DECISION DELEGATED TO DEVELOPMENT MANAGER

Application No: H09-1225-19 **Applicant:** University Academy Holbeach

Proposal: Erection of new two-storey, six classroom block - approved under H09-0838-19 - amendments to elevations

Location: University Academy Holbeach Park Road Holbeach

Proposed Plans & Elevations

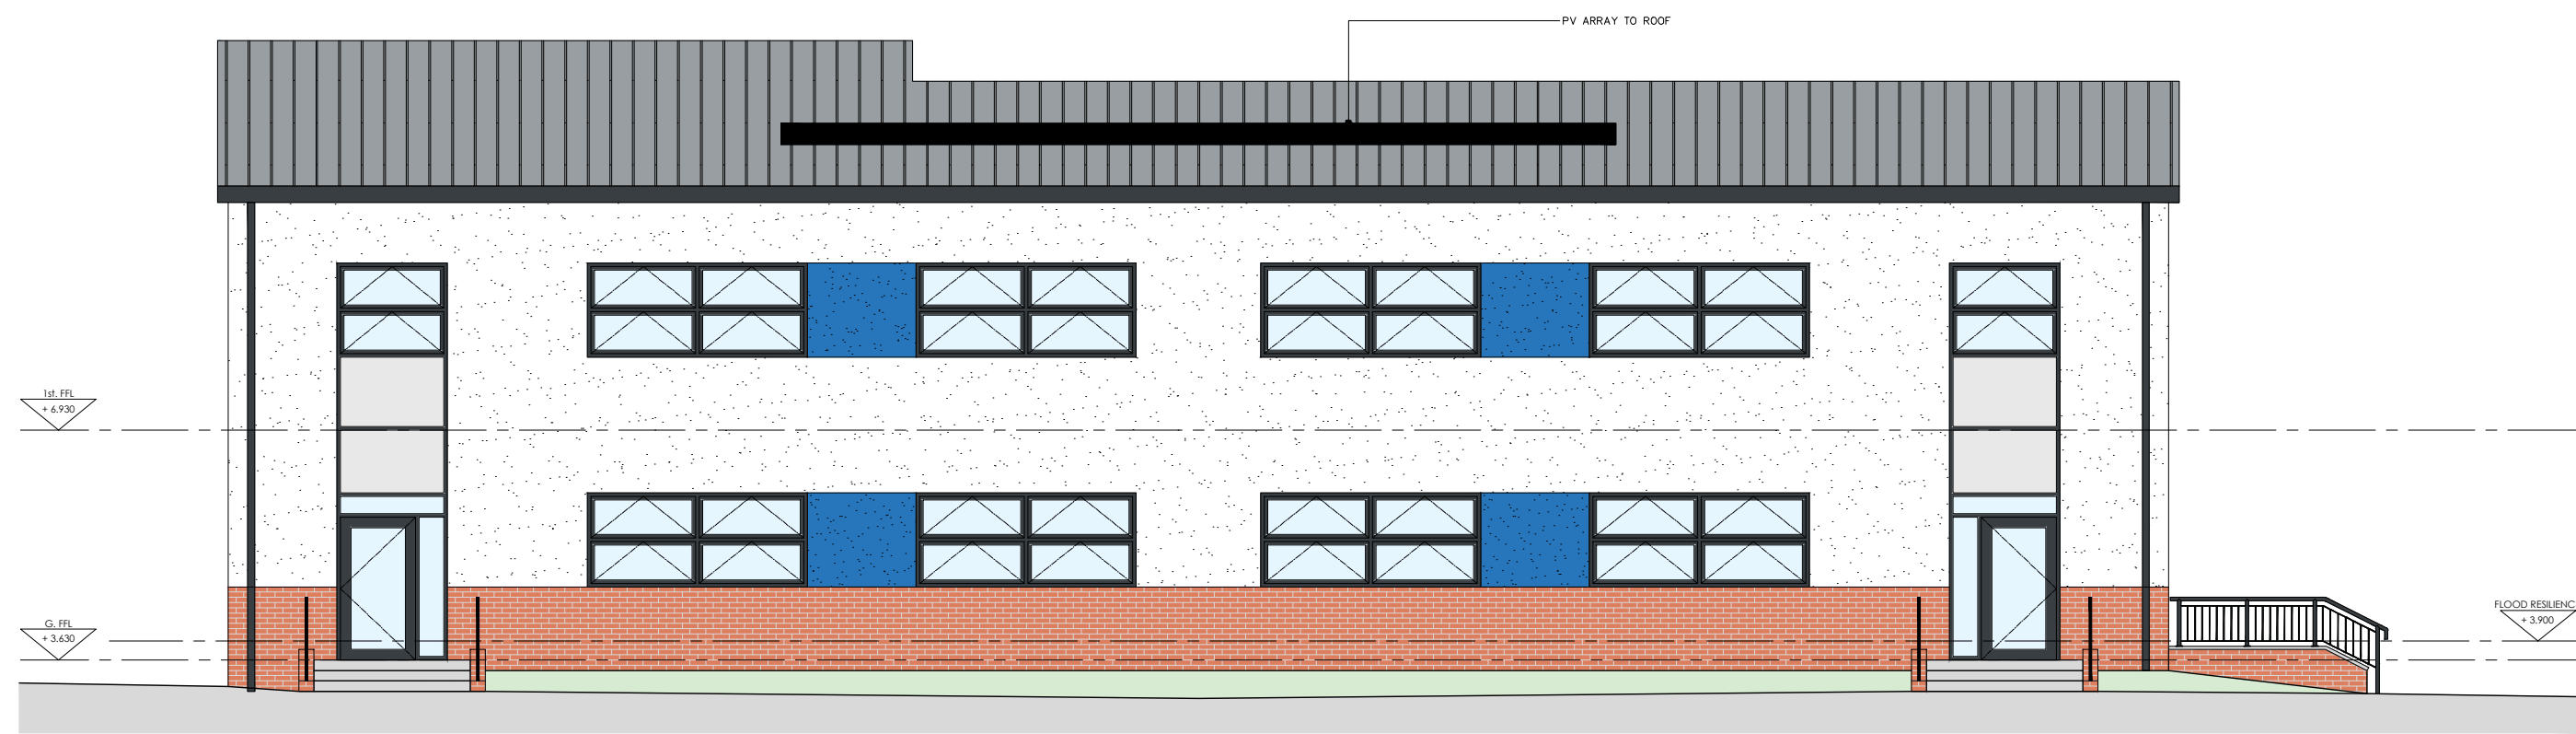
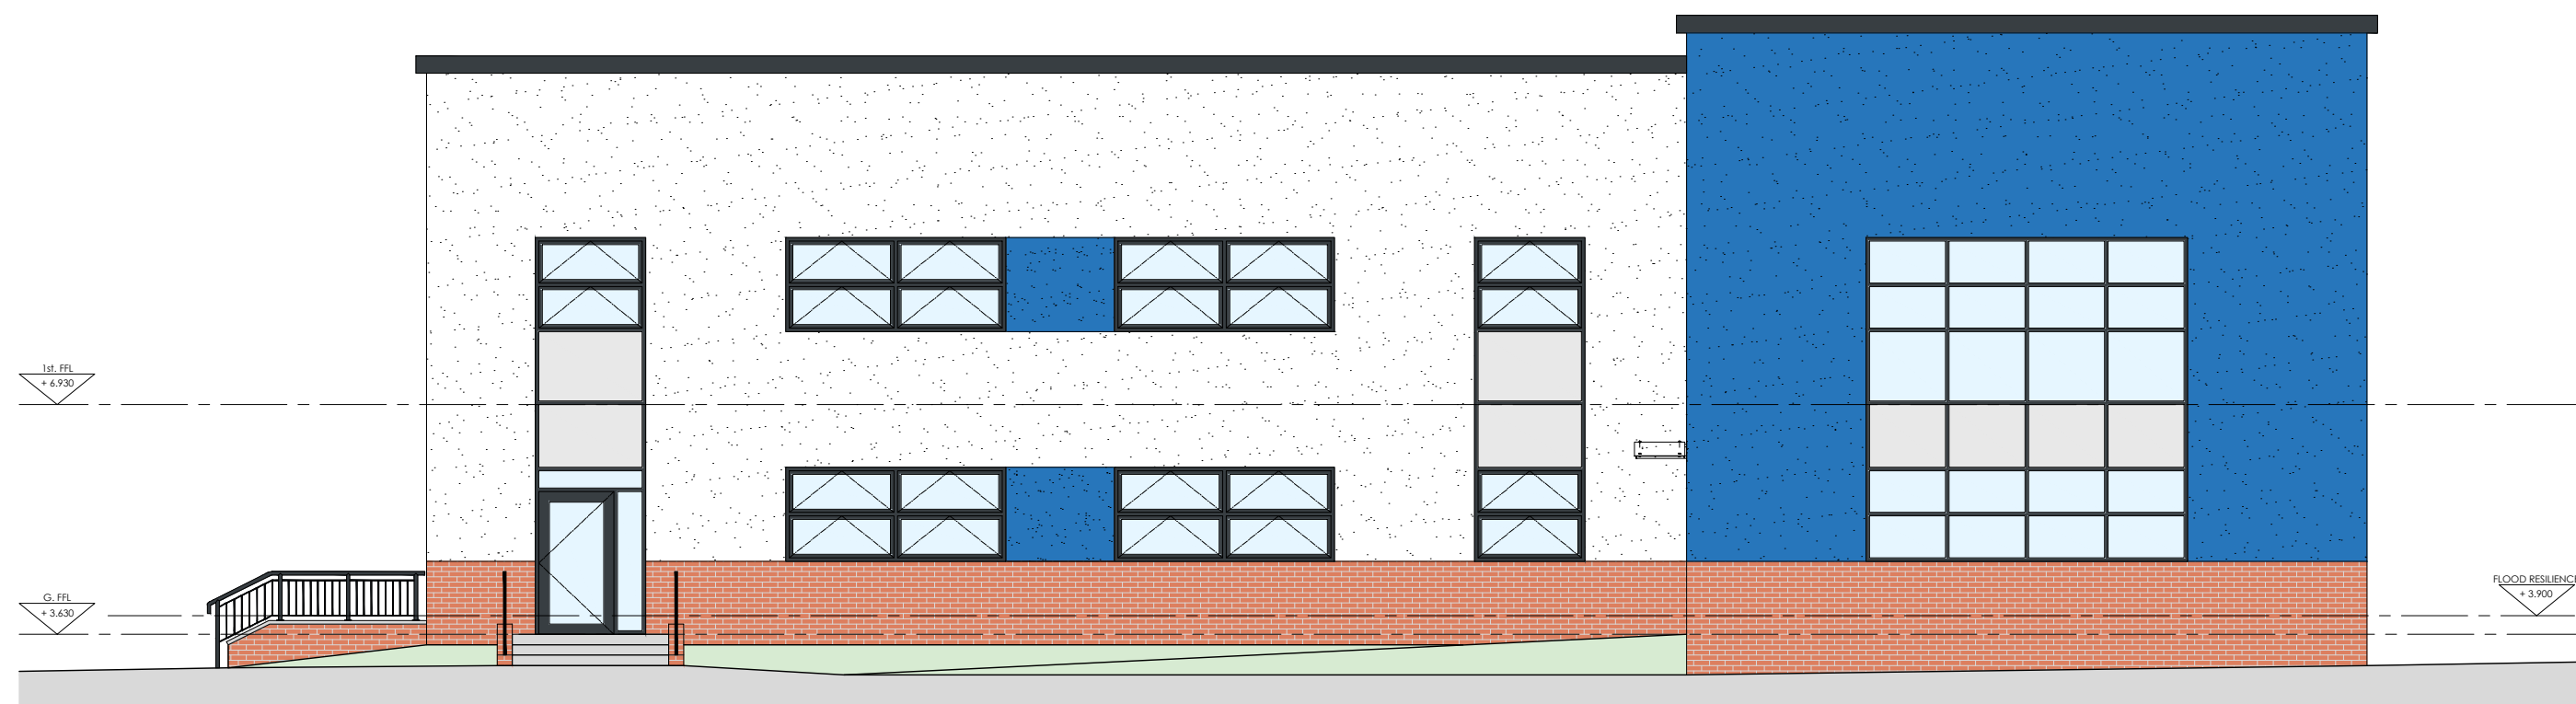
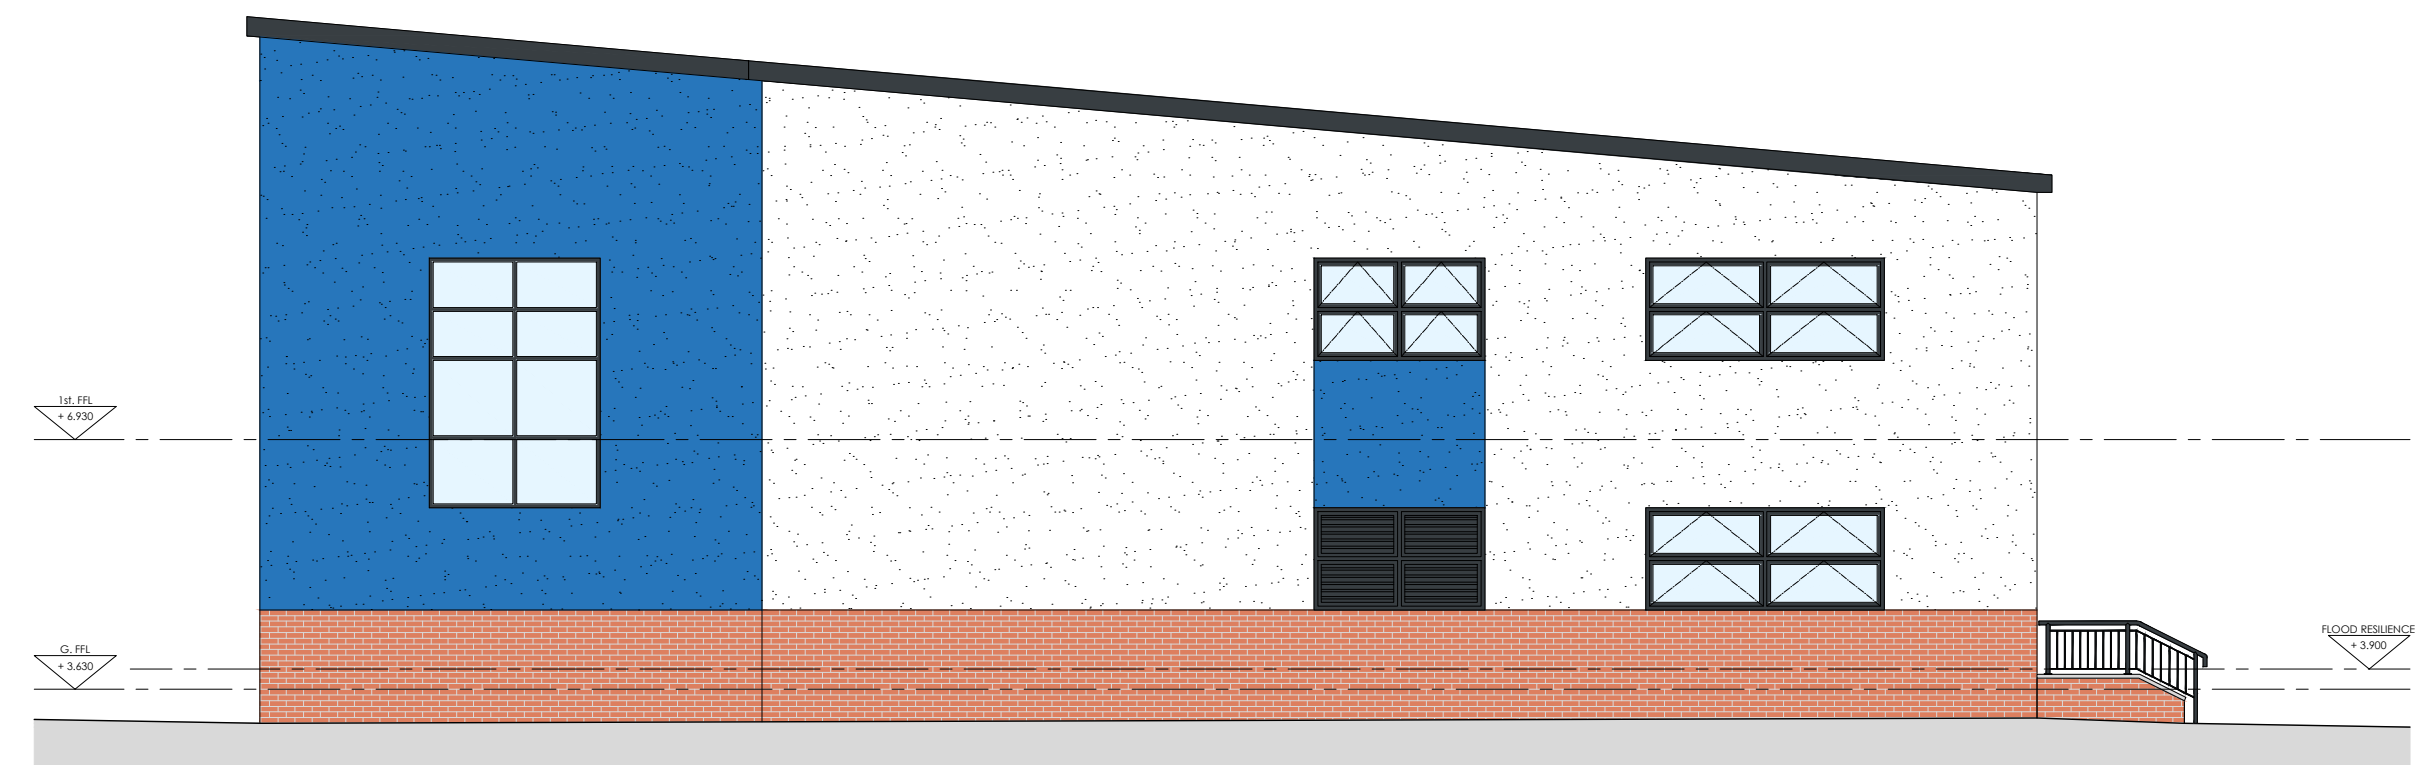
The amendment is essentially for elevation changes; namely,

- Omission of Brise Soleil;
- Addition of PV array to roof;
- Rationalise extents of curtain walling;
- Addition of canopy over main entrance.

The proposed alterations would not result in a fundamental change in the design of the building and would not exacerbate any impact upon neighbours.

It is considered that the proposal satisfactorily complies with the criteria of the South Holland District Council's Development Control Procedure Note Non-Material Amendments to Planning Permissions, and as such is acceptable as a Non-Material Amendment.
